(3512) Southern Schools Cluster (SSC)

Re: GANSW Comment on Booster for NLPS SSD

We have received the below comment on the NLPS SSD from the Government Architect's Office.

Drawing Title
SITE PLAN - PROPOSED

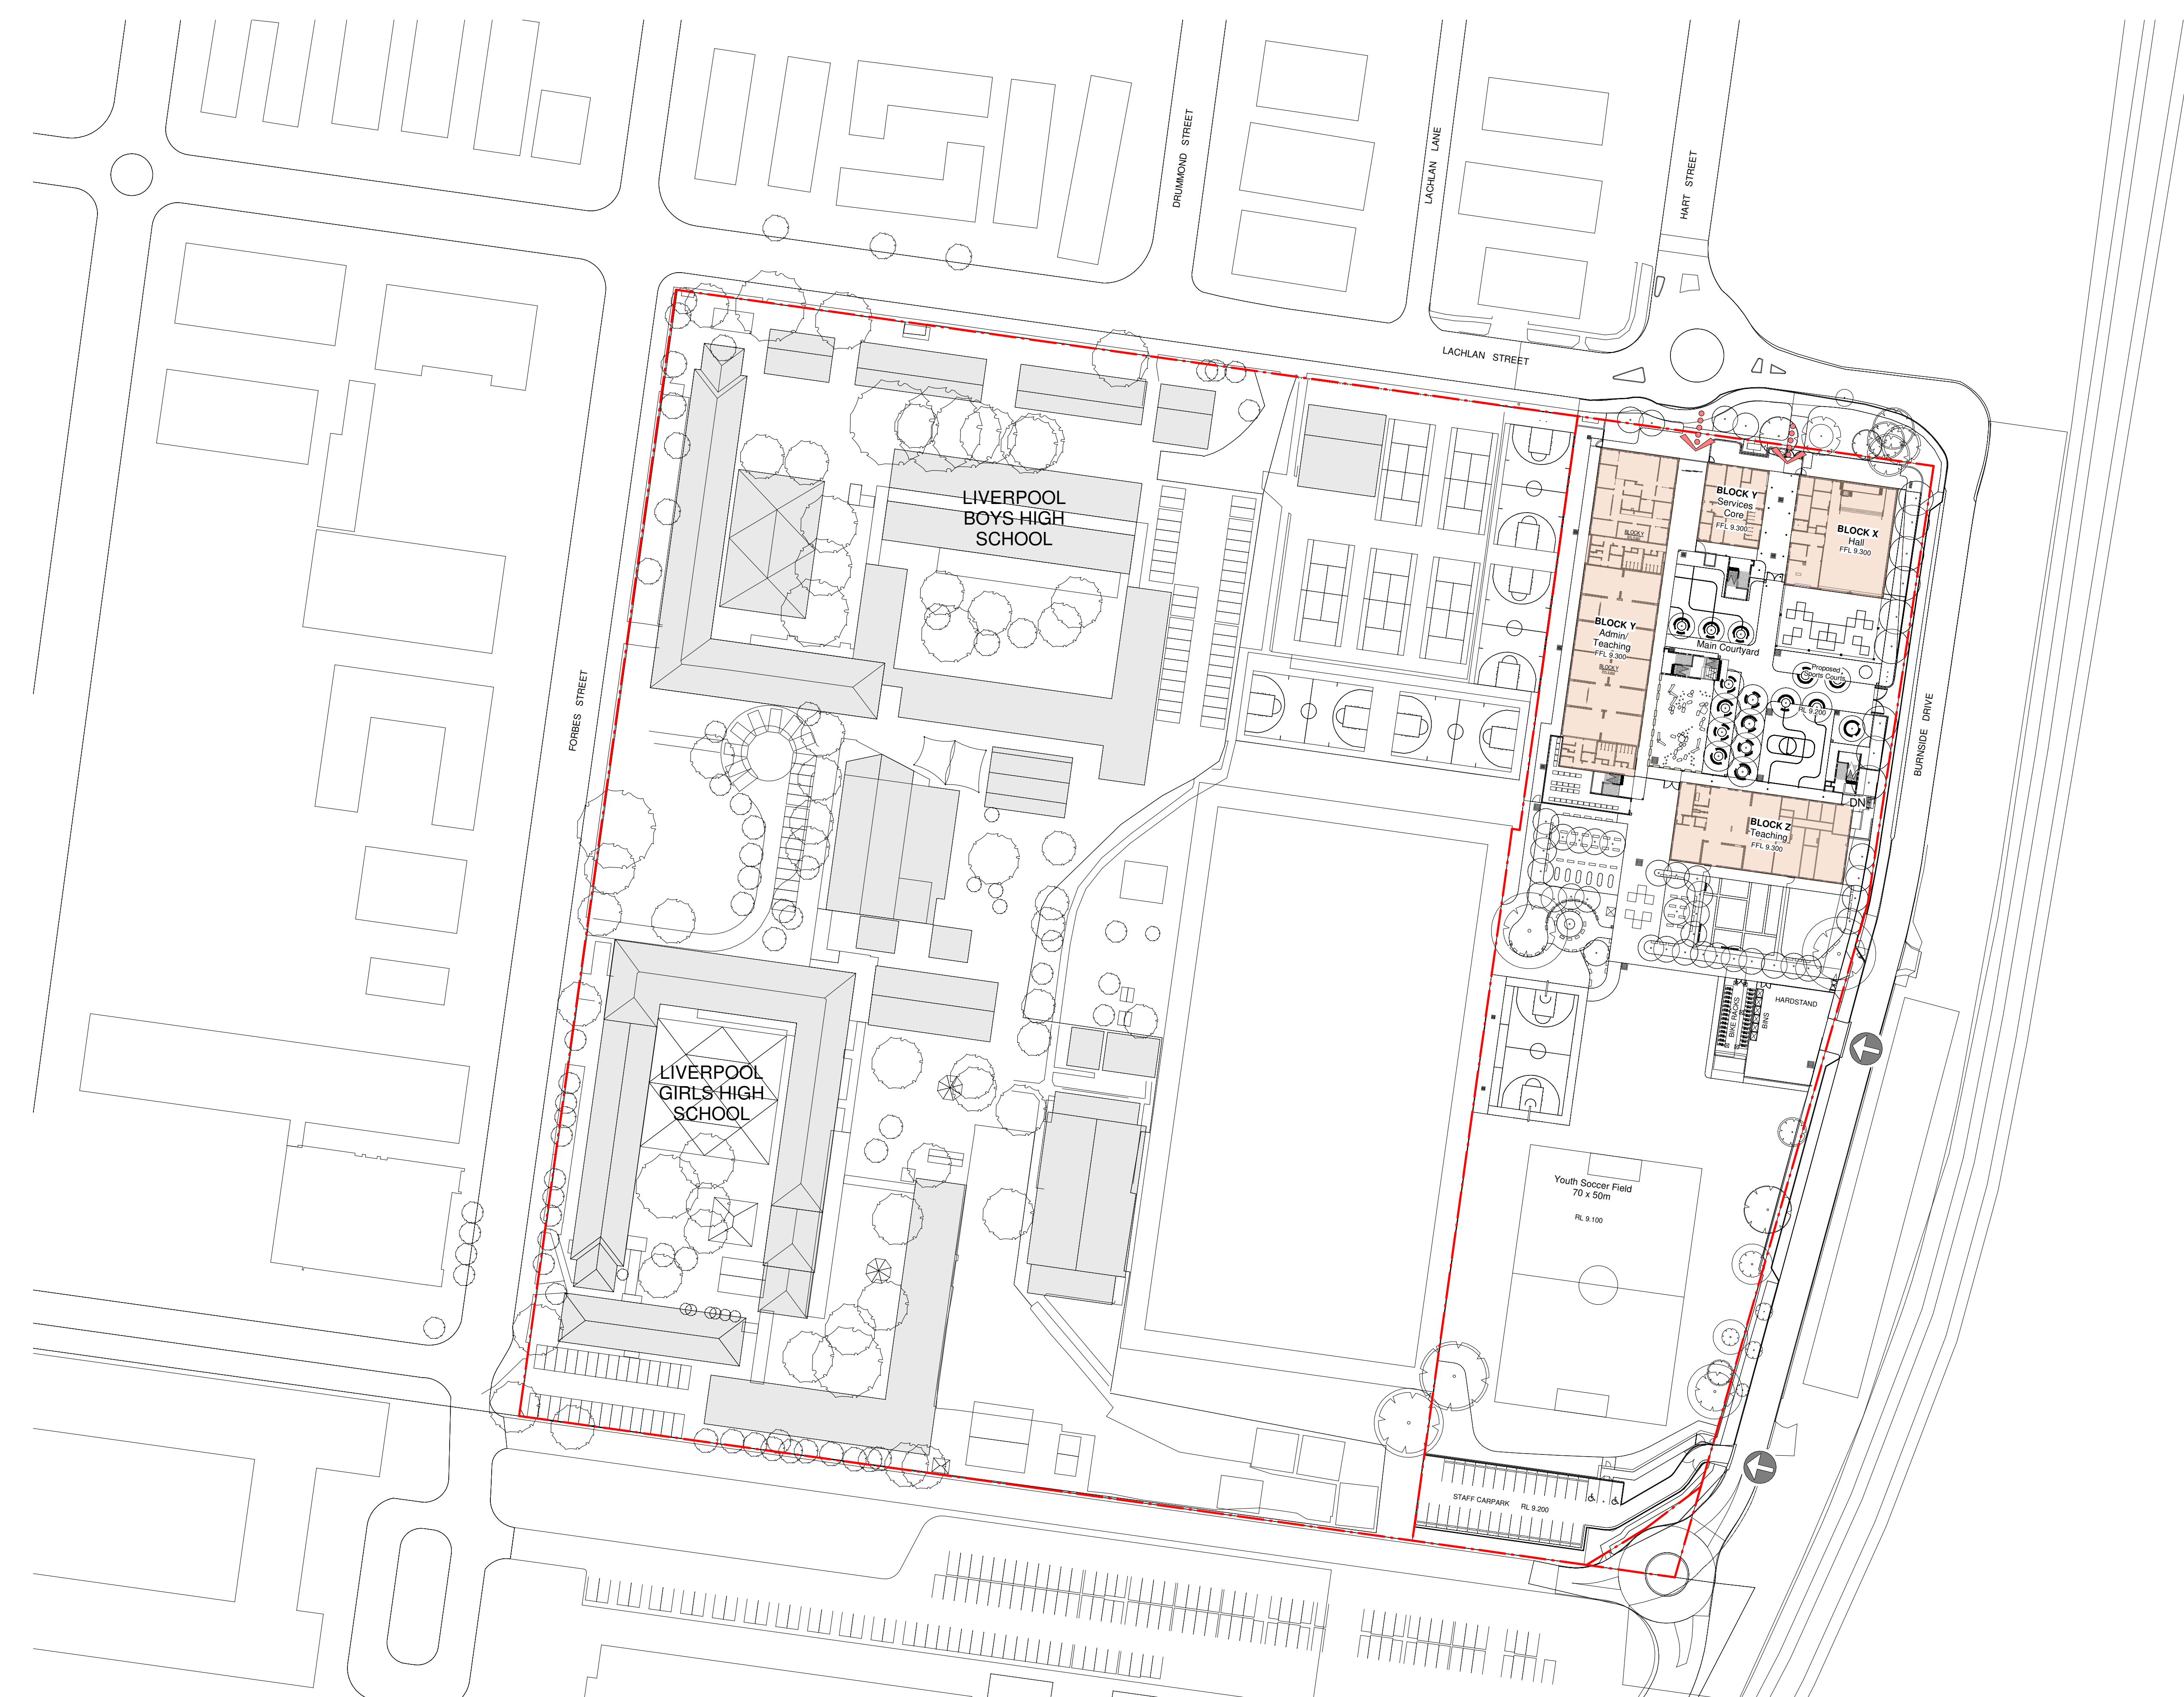
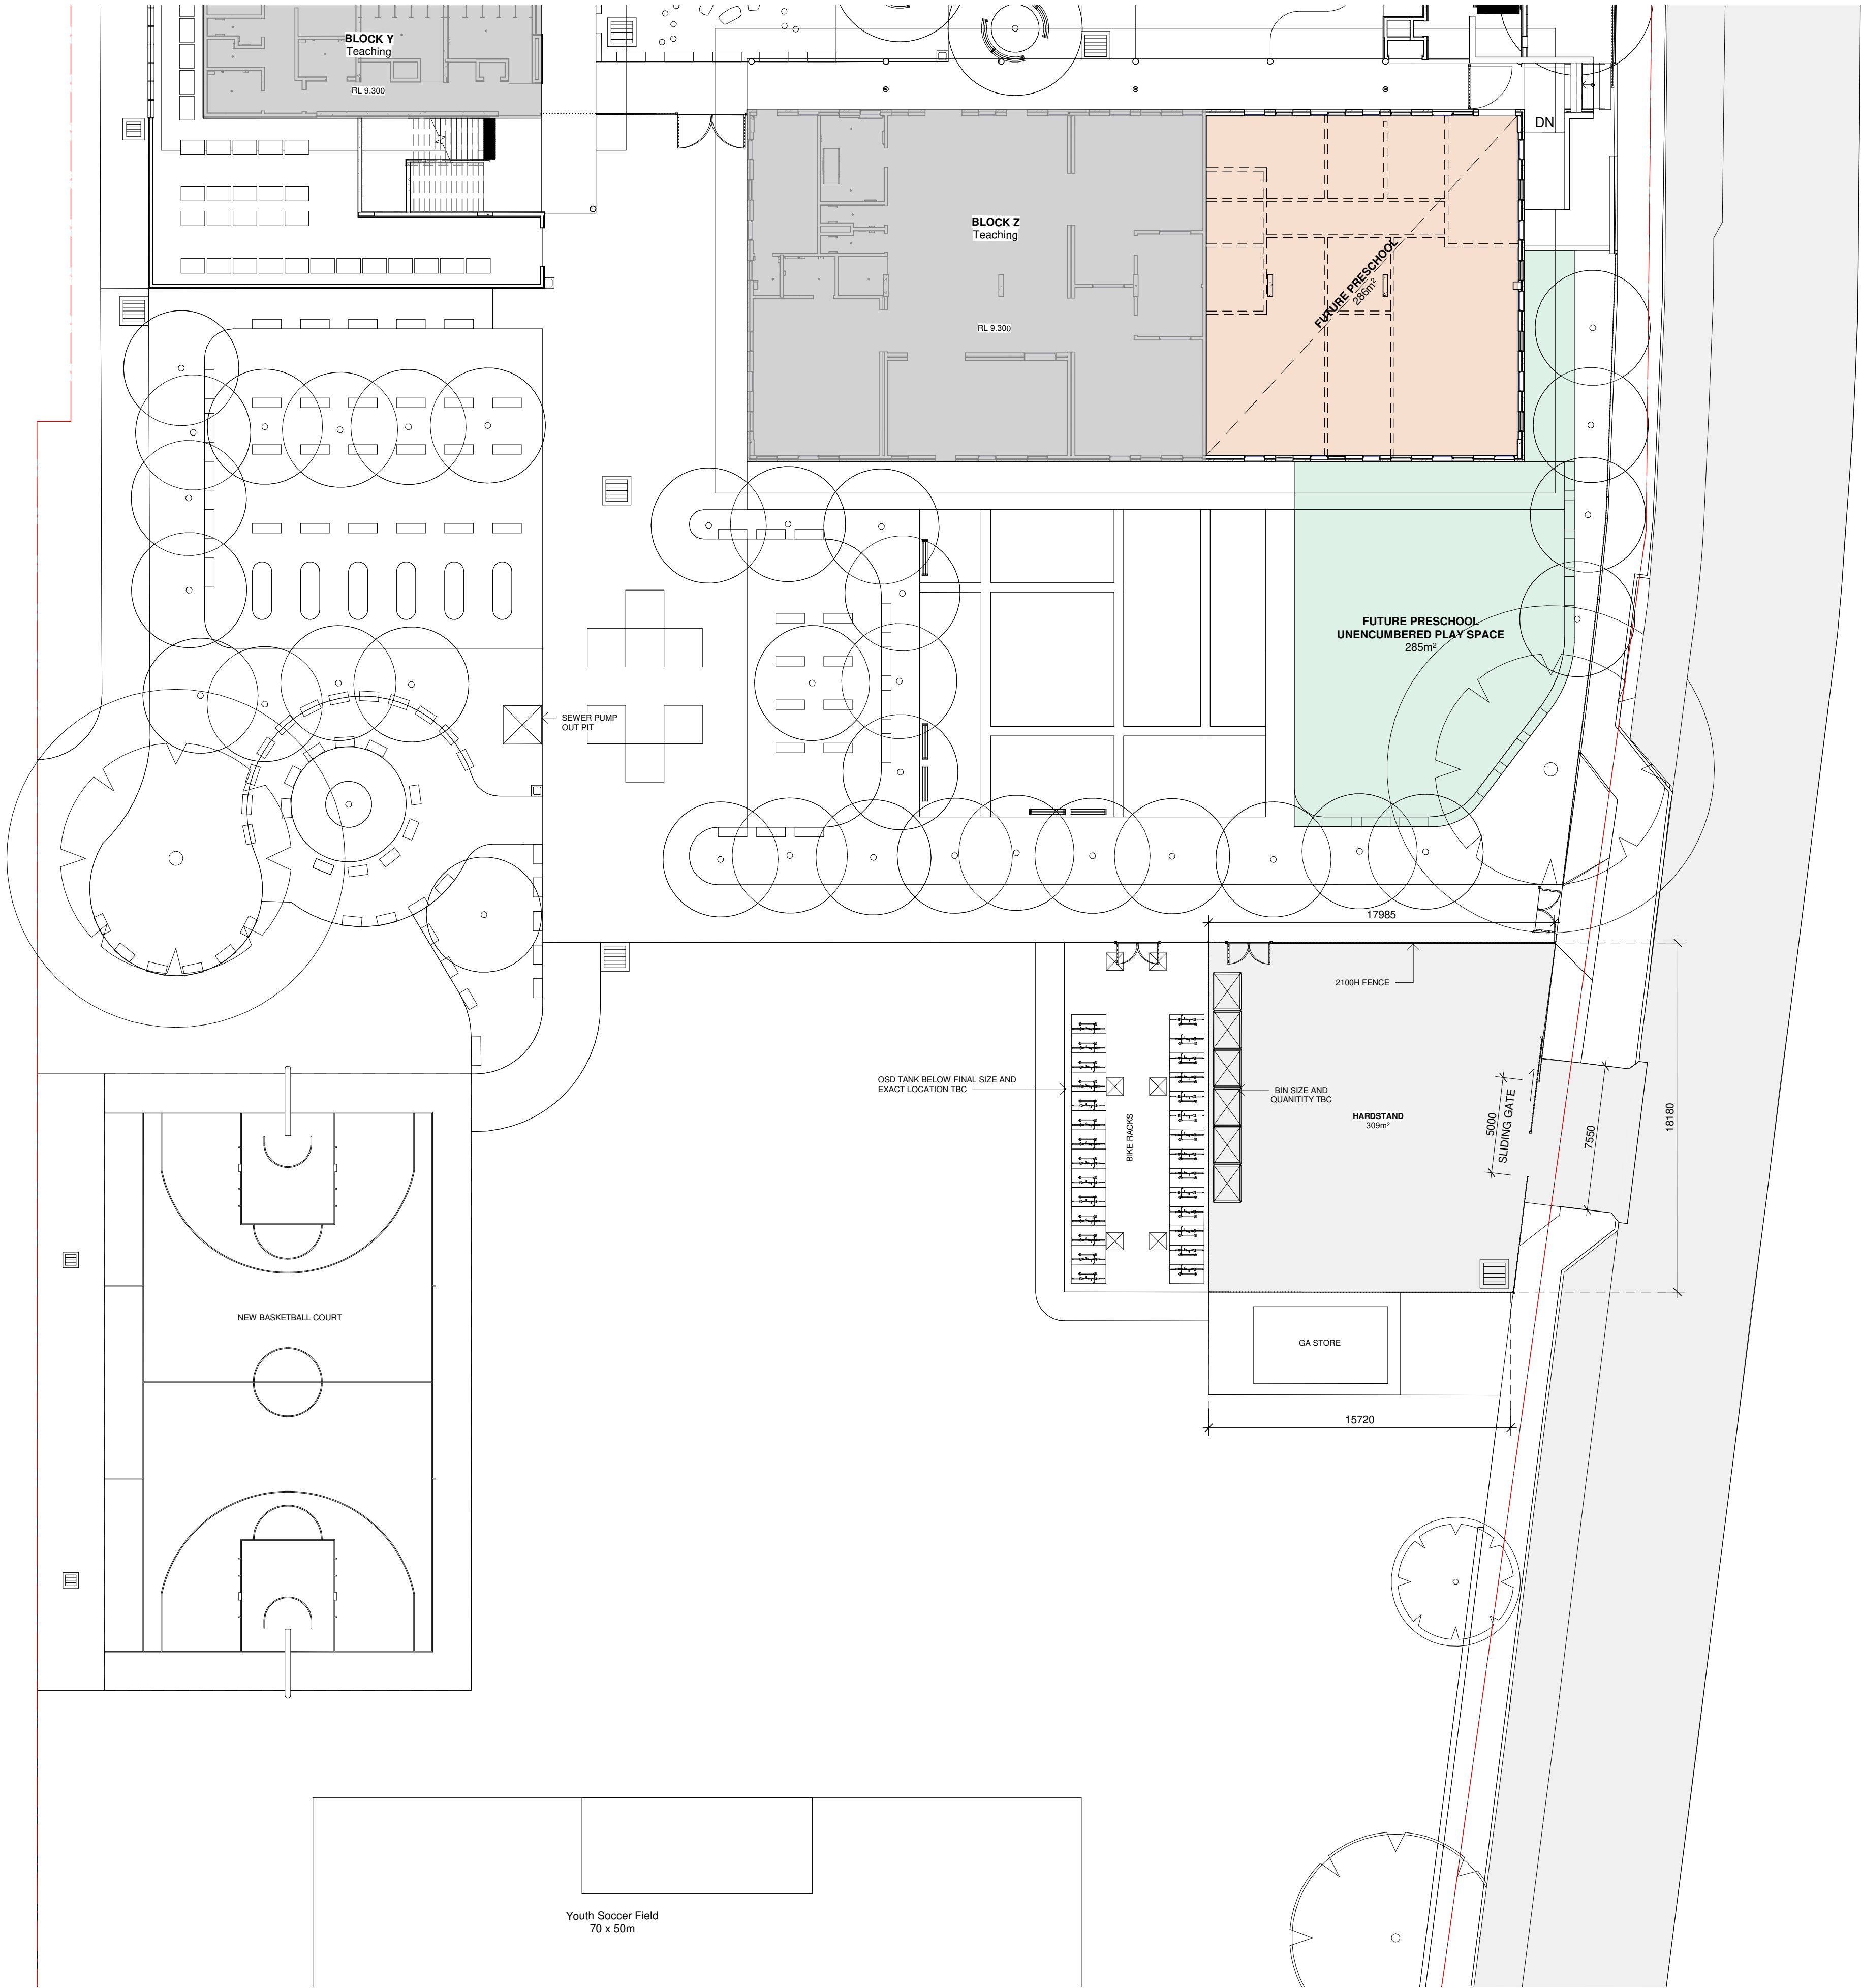
the booster near the main entrance, should be concealed to improve the amenity of this public zone.	S
---	---

Are you able to provide a very brief statement today explaining to GANSW that, from a compliance perspective, we cannot screen the front of the booster?

My understand is that the only method of concealing a fire brigade booster assembly permitted by AS 2419.1 - 2005 is via a cabinet designed in accordance with this standard (50mm high signage, clear space in front of the assembly maintained, cabinet generally painted red, etc.).

There would be no opportunity to provide any further shielding or screening as this would obstruct the clear space between the booster and the hardstand (the road). Further noting that providing any form of landscaping in front of the booster would not meet FRNSW's operational requirements (based on past experience of having to concrete areas in front of booster assemblies where FRNSW has picked this up as an issue on site).
